**The Planning Act 2008 - Section 89 and The Infrastructure Planning (Examination Procedure)
Rules 2010 - Rule 8 (as amended)
Application by Highways England for an Order Granting Development Consent for the A303
Sparkford to Ilchester Dualling**

From: Carleton Earl.
Area Footpath Secretary, Somerset Ramblers
Fulwood House
Winsham
Chard TA20 4EE

**The Planning Act 2008 - Section 89 and The Infrastructure Planning (Examination Procedure) Rules 2010 - Rule 8 (as amended)
Application by Highways England for an Order Granting Development Consent for the A303 Sparkford to Ilchester Dualling**

INSET G: EXISTING ROADS AND PROW TO BE STOPPED UP

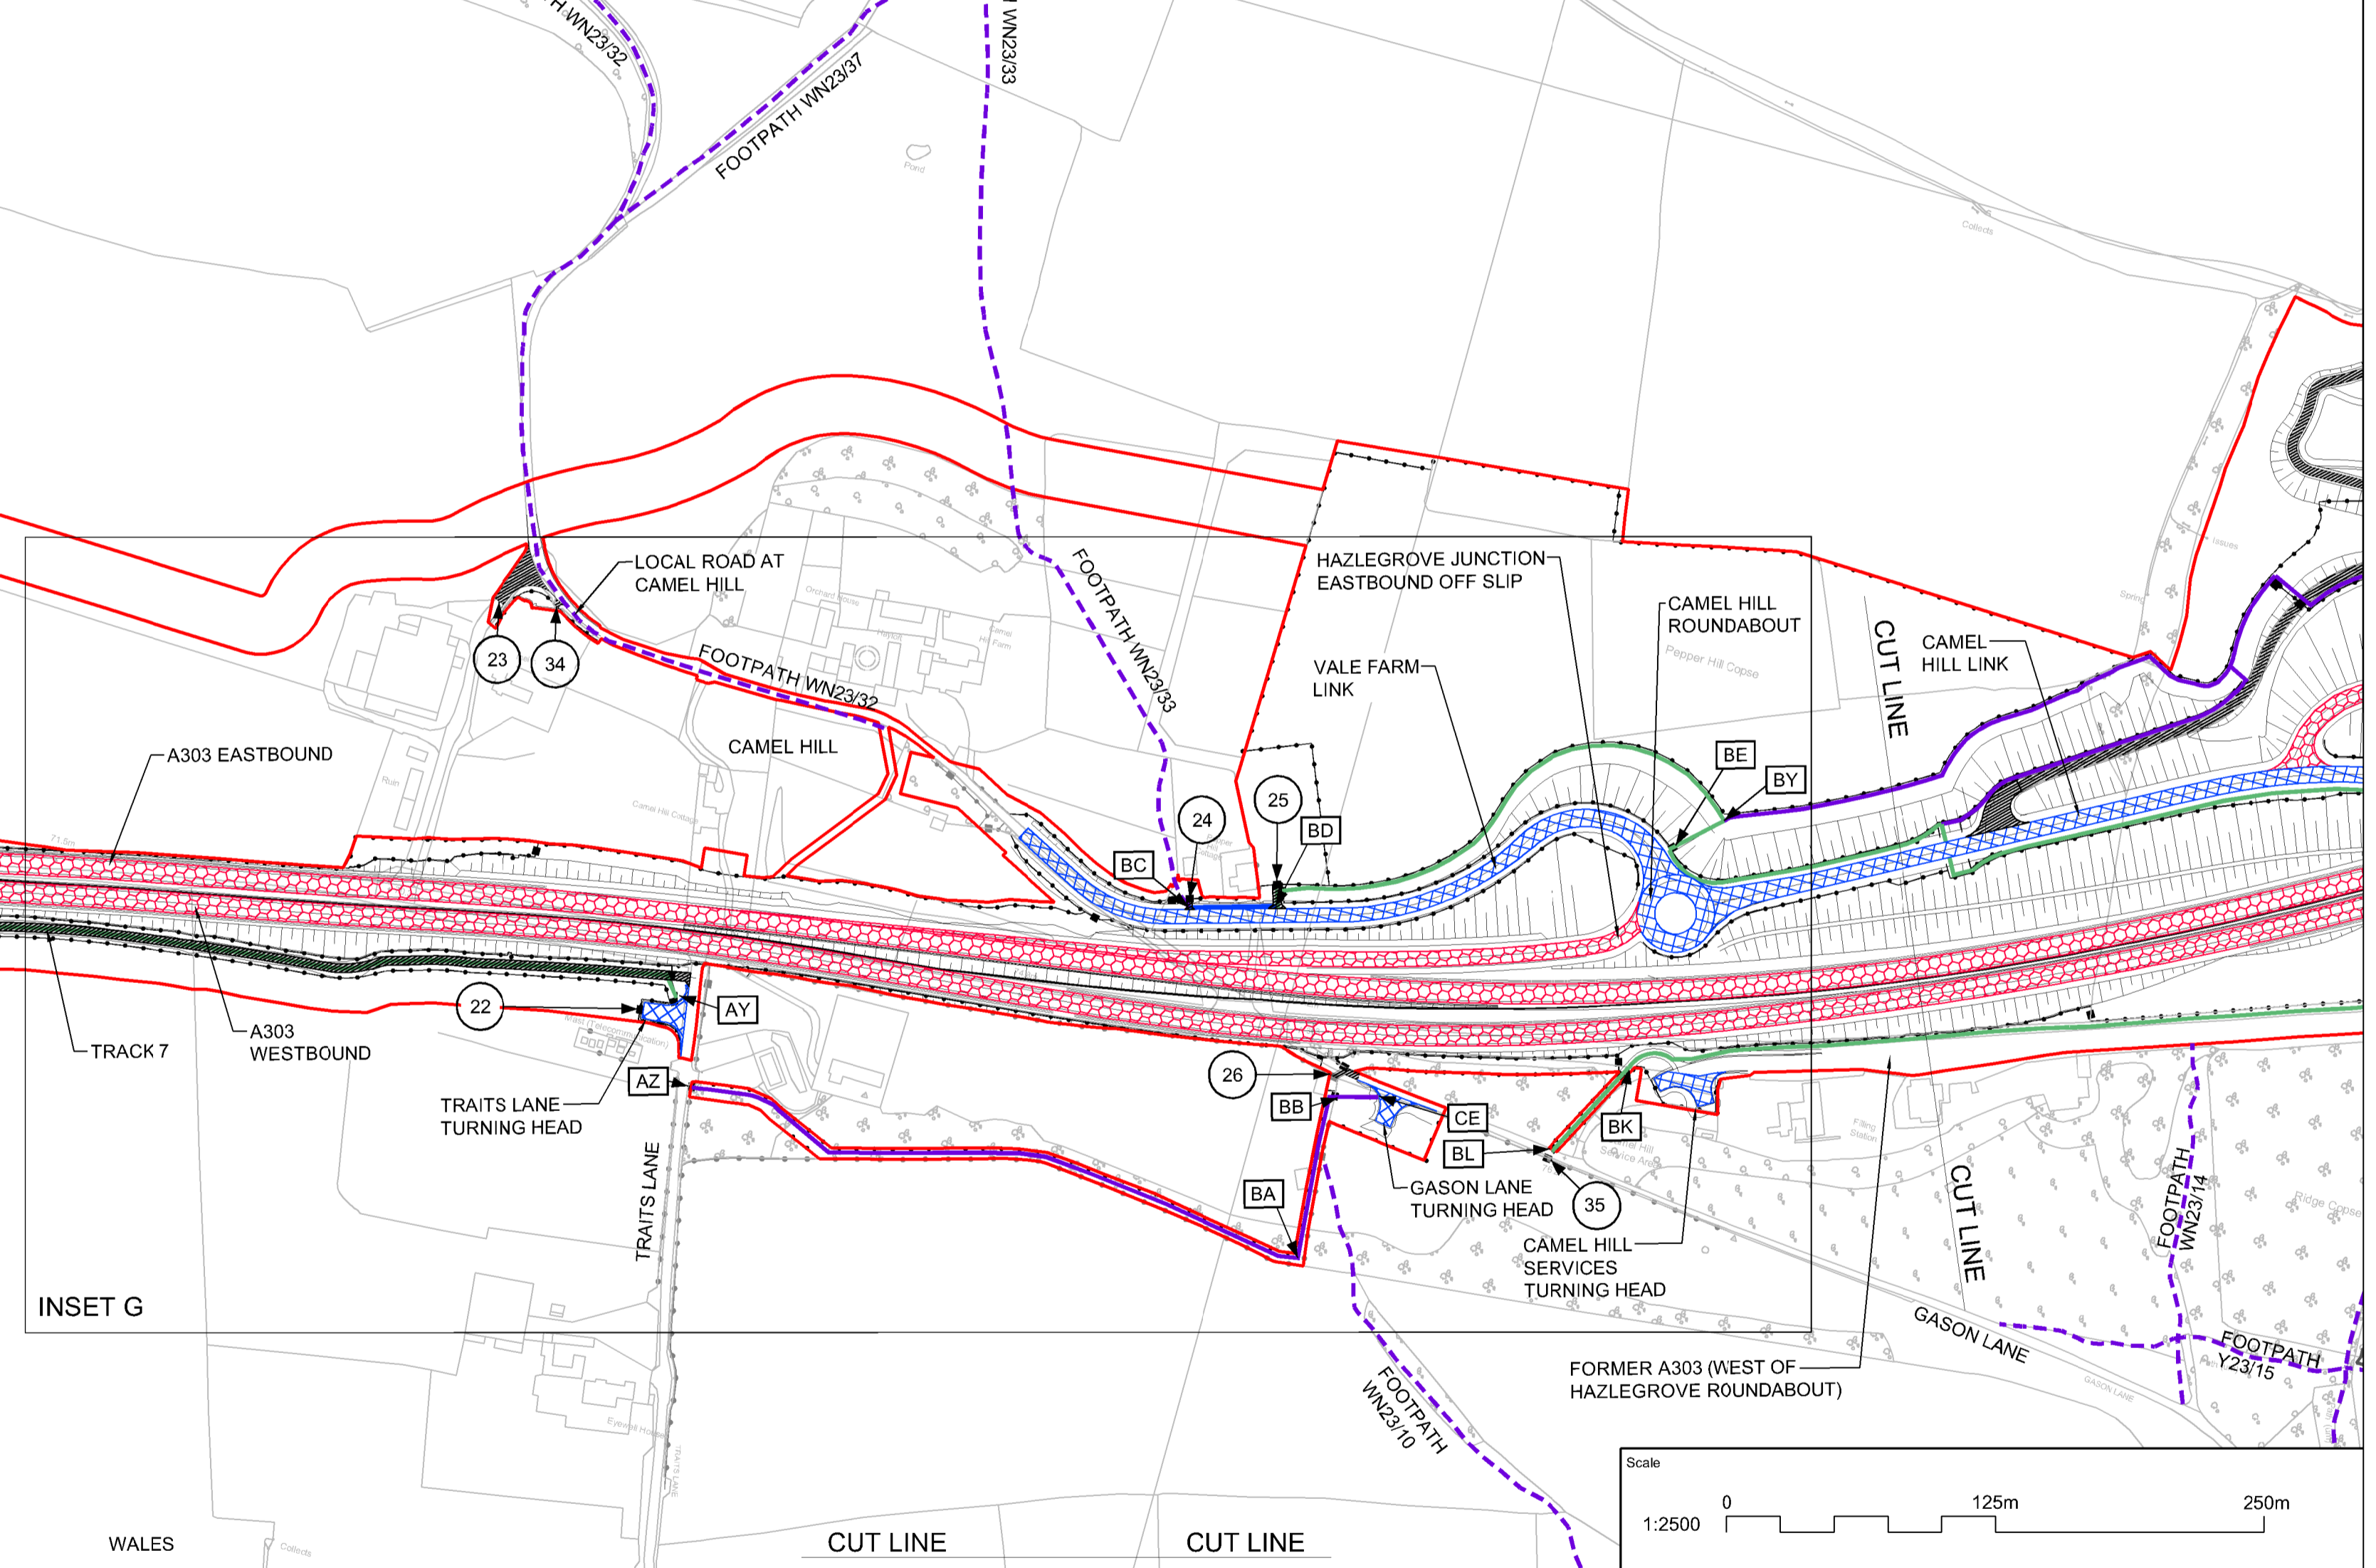
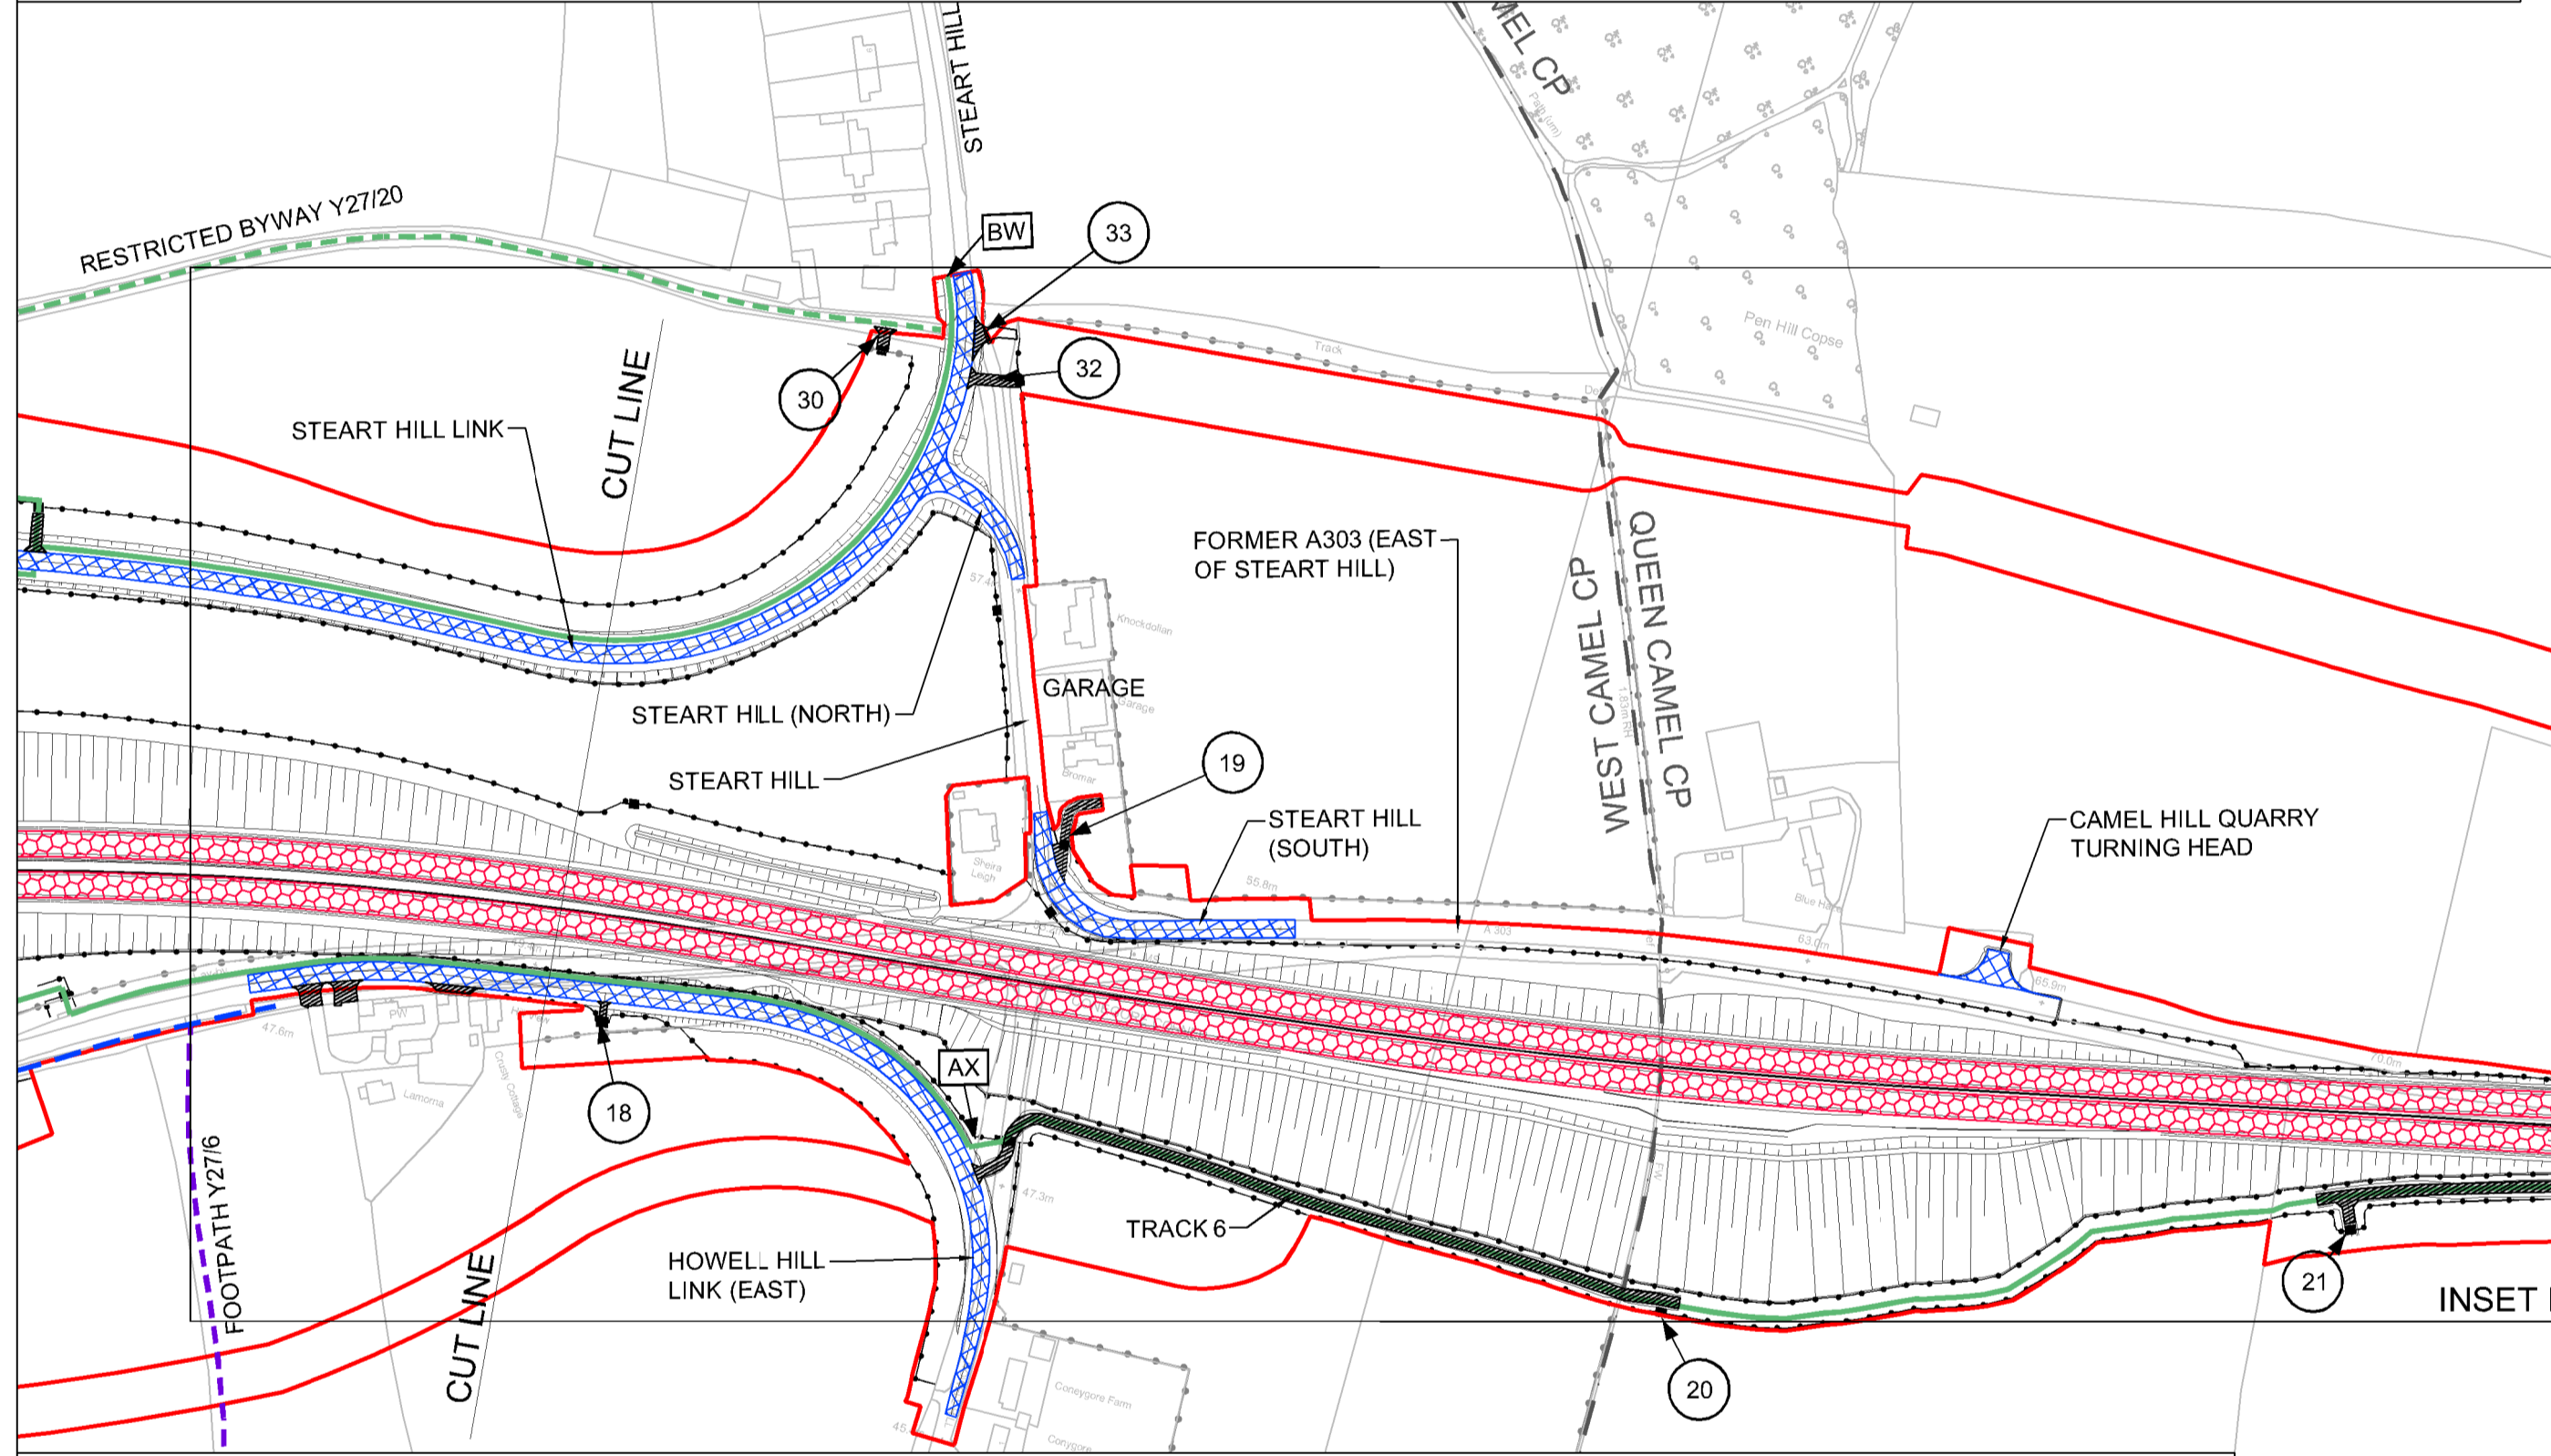
2. Part 1 of Schedule – Queen Camel – stopping up of Traits Lane and WN 23/32, 23/10 & 23/3.
Somerset Ramblers would ask that consideration be given to the provision of a pedestrian bridge in the general vicinity of Traits Lane where it meets the new road with appropriate connecting links to the above footpaths to provide safe connection between routes to the north and south of the new road. To require walkers to go east to cross at Hazelgrove roundabout means an extensive diversion and walking alongside and crossing what will remain well used roads.
